From: Michael Balaskovits
Sent: Tuesday, July 26, 2016 9:09 AM
To: Rebecca Gauna
Subject: Fwd: Desert Hills, 5200 Bldg C Sequoia Rd., 30-day CO

From: "Carrillo, Abiel X." <acarrillo@cabq.gov>
Date: July 14, 2016 at 3:55:21 PM MDT
To: Michael Balaskovits <mbalaskovits@bhinc.com>
Cc: "Ortiz, Monica" <mortiz@cabq.gov>, "Elliott, Stanice" <staniceelliott@cabq.gov>, Harmon Rita T. <rharmon@cabq.gov>
Subject: RE: Desert Hills, 5200 Bldg C Sequoia Rd., 30-day CO

From: Harmon Rita T.
Sent: Friday, June 17, 2016 4:26 PM
To: 'Michael Balaskovits'
Cc: Cordova, Camille C.; Miranda, Rachel; Sandoval, Darlene M.; Blocker, Lois
Subject: Desert Hills, 5200 Bldg C Sequoia Rd., 30-day CO

4 TYPICAL COURTYARD GRADING  
1" = 5'

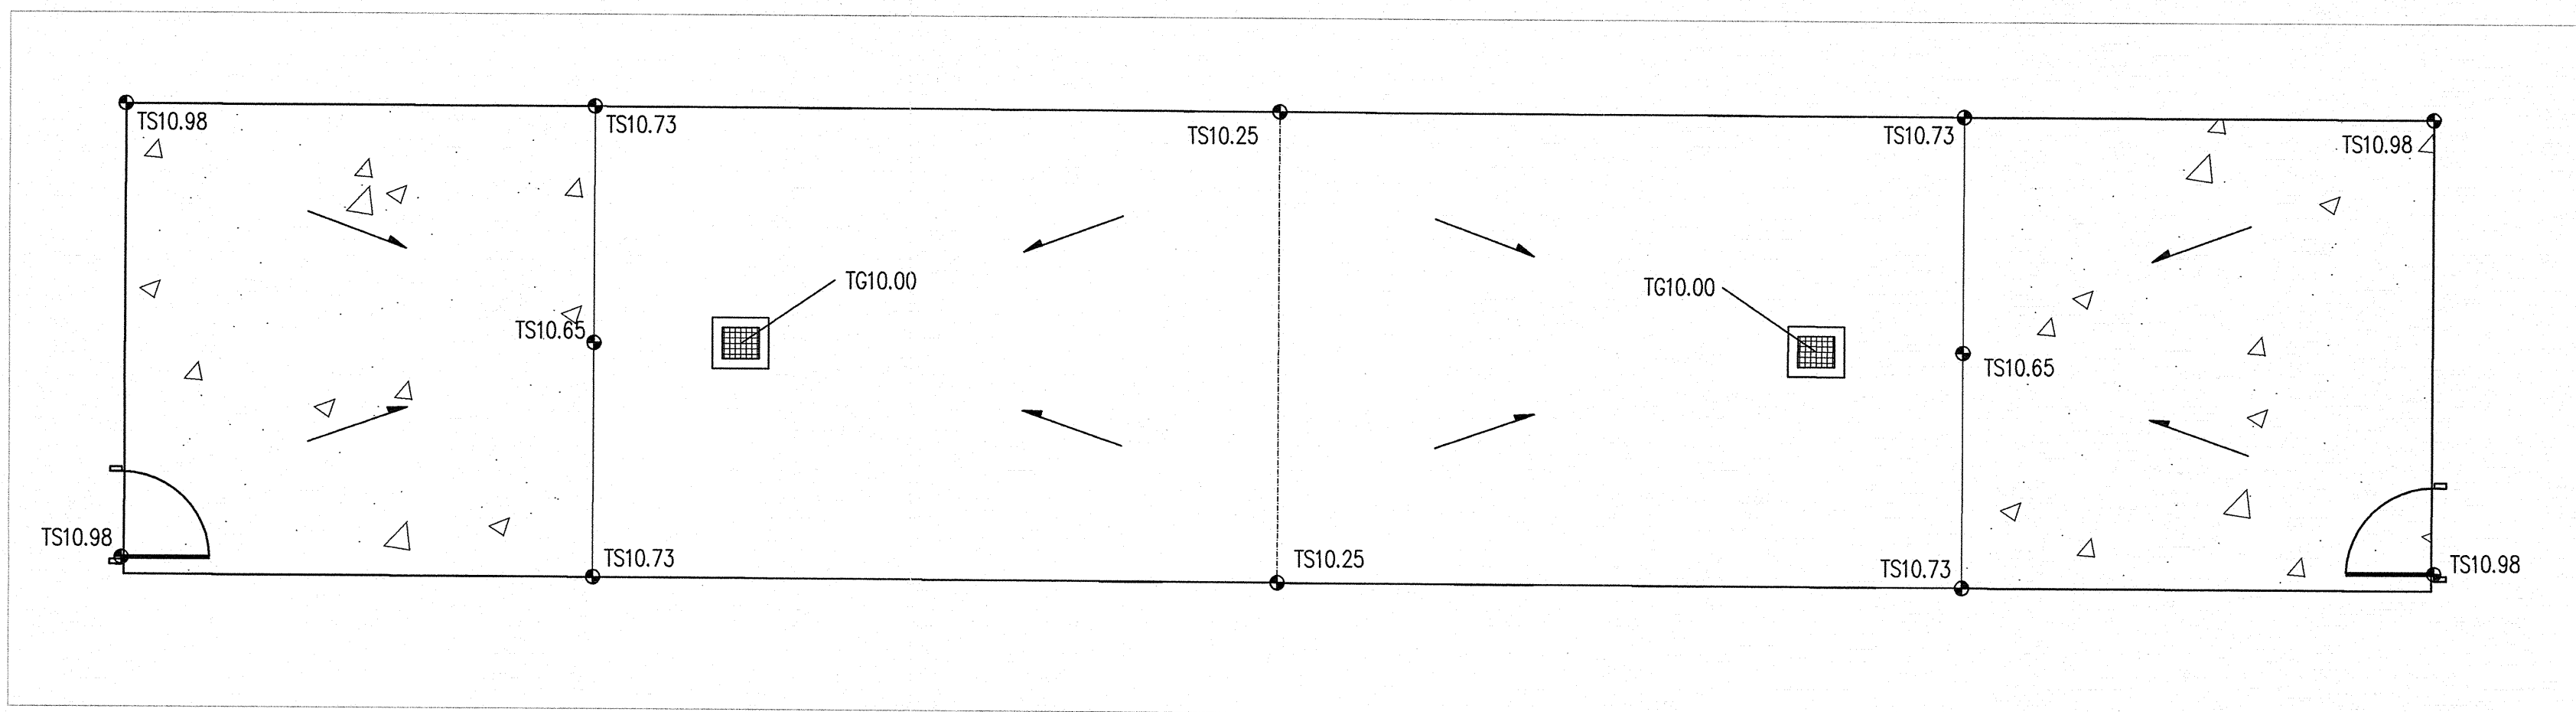
It seems acceptable, only modify the detail so that the crusher fines don't creep into the grate. (see pic – although a bit exaggerated)

Hi Mike,
This does not appear to be a permanent solution since maintenance personal changes throughout the life of a site.
A concrete collar with a depression, or a curb-type collar is what we discussed on the phone.

I can help. I remember Rita mentioning this project. The collars look acceptable to me, so you can consider the item addressed.

The manhole collar in dirt areas from the standard drawings was what I was thinking. See attached.

Thanks for the reply Rita. The contractor is going to head out there Thursday. I wanted to confirm that the collar constructed would suffice moving forward? In addition would a collar similar to a manhole collar not constructed in a paved area work? Almost like a dome collar?
